23 December 2019

Belmont Drought Response Desalination Plant (SSI 8896) Response to Submissions

Attachment 1: Key Issues

TITLE: CS0865 TEMPORARY DESALINATION PLANT CONCEPT DESIGN SITE LAYOUT			SIZE: A1	SCALE: 1:750	INDEX No. -	DRAWING No. 15830	SHEET 010	REV No. 0A
---	--	--	-------------	-----------------	----------------	----------------------	--------------	---------------

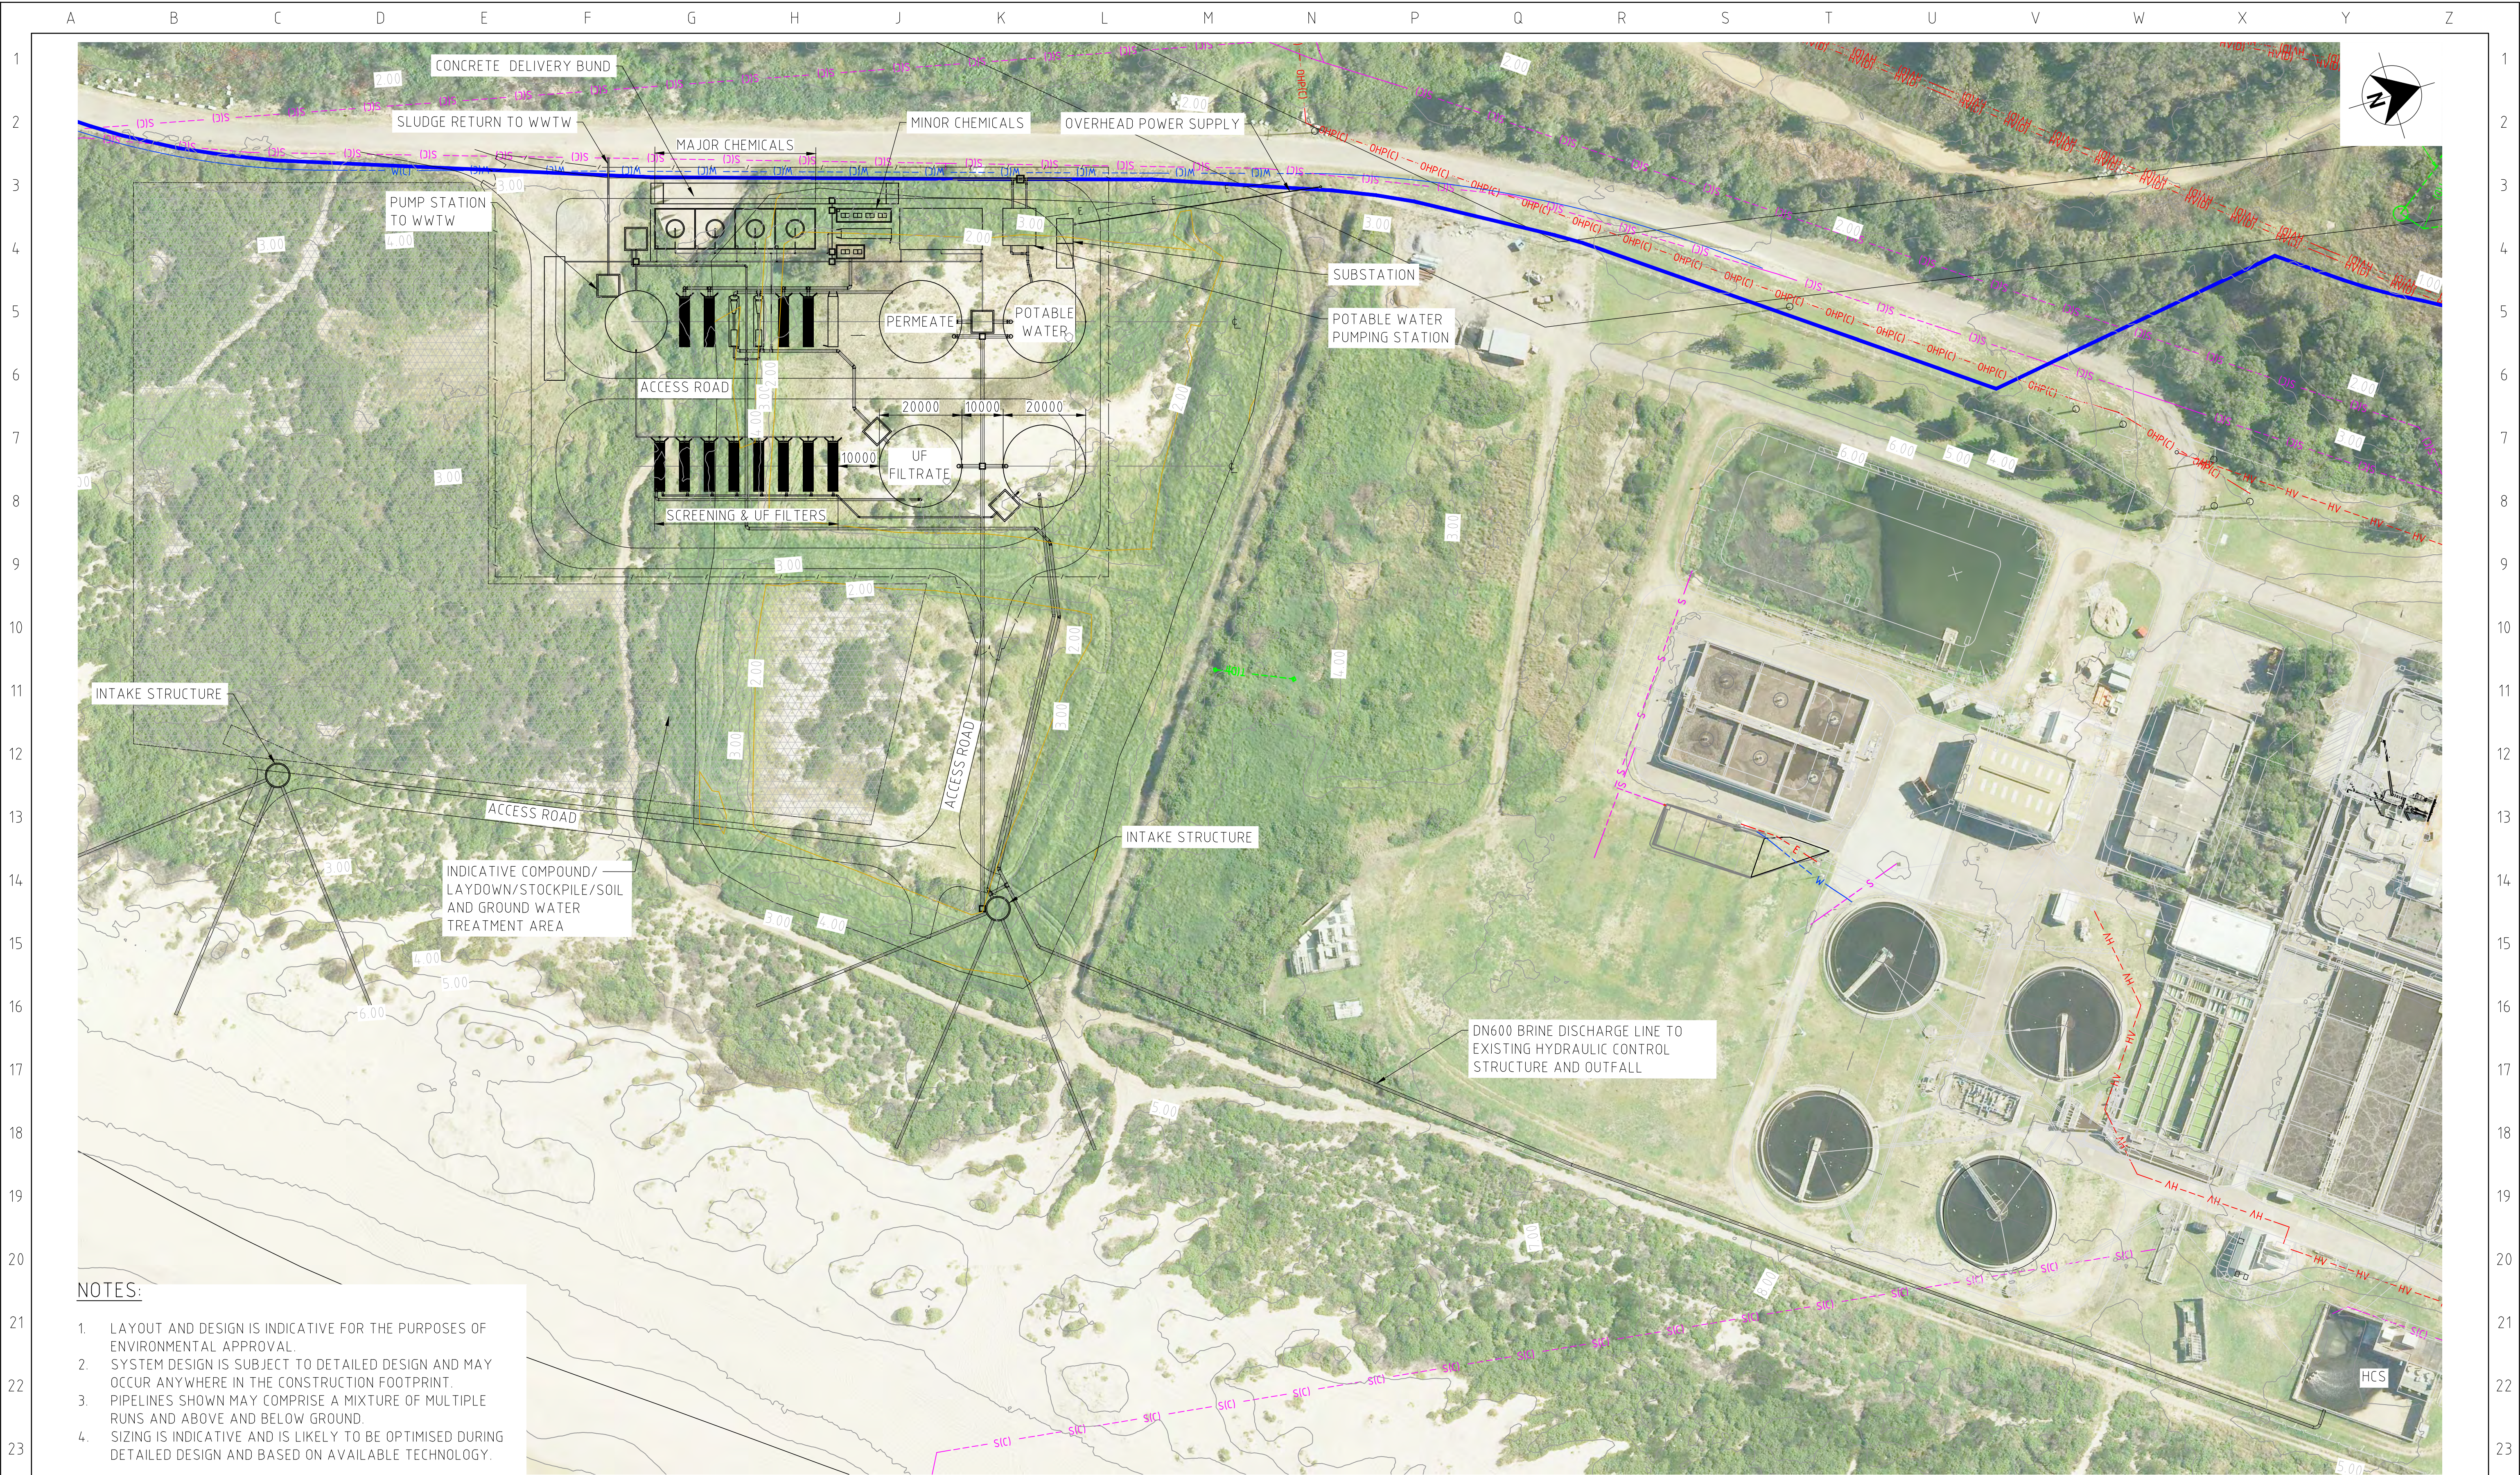
- Based on Concept Design drawings provided, a significant proportion of the disused evaporation pond area will be utilised for the purposes of the desalination plant, as such additional detail is required in relation to stormwater and drainage flows around the proposed infrastructure.
- Consideration of *Guidelines for development adjoining land and water management by DECCW* (OEH, 2013).
